From: Slaidburn and Easington Parish Council c.o Alison Robinson
Sent: 03 April 2022 22:12
To: Planning
Subject: FAO Stephen Kilmartin Consultation on planning application, 3/2022/0227, Lower Edge Farm Tinklers Lane Slaidburn BB7 4TP
Attachments: 22 0227 Email Consultation.pdf
Categories: To Upload

The application is for - Erection of an agricultural building and improved gate access. Resubmission of 3/2021/1046.

SITE PLAN 003

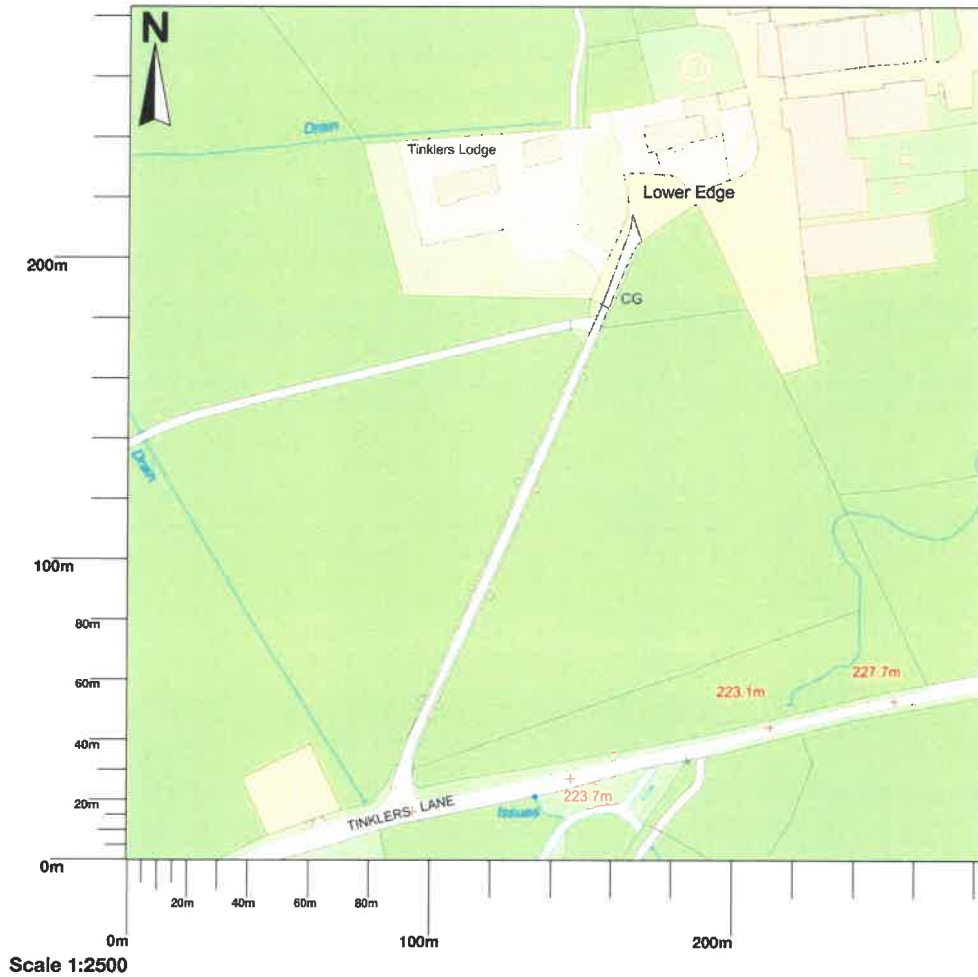
They believe that the building should be built in closer proximity to the farmstead.
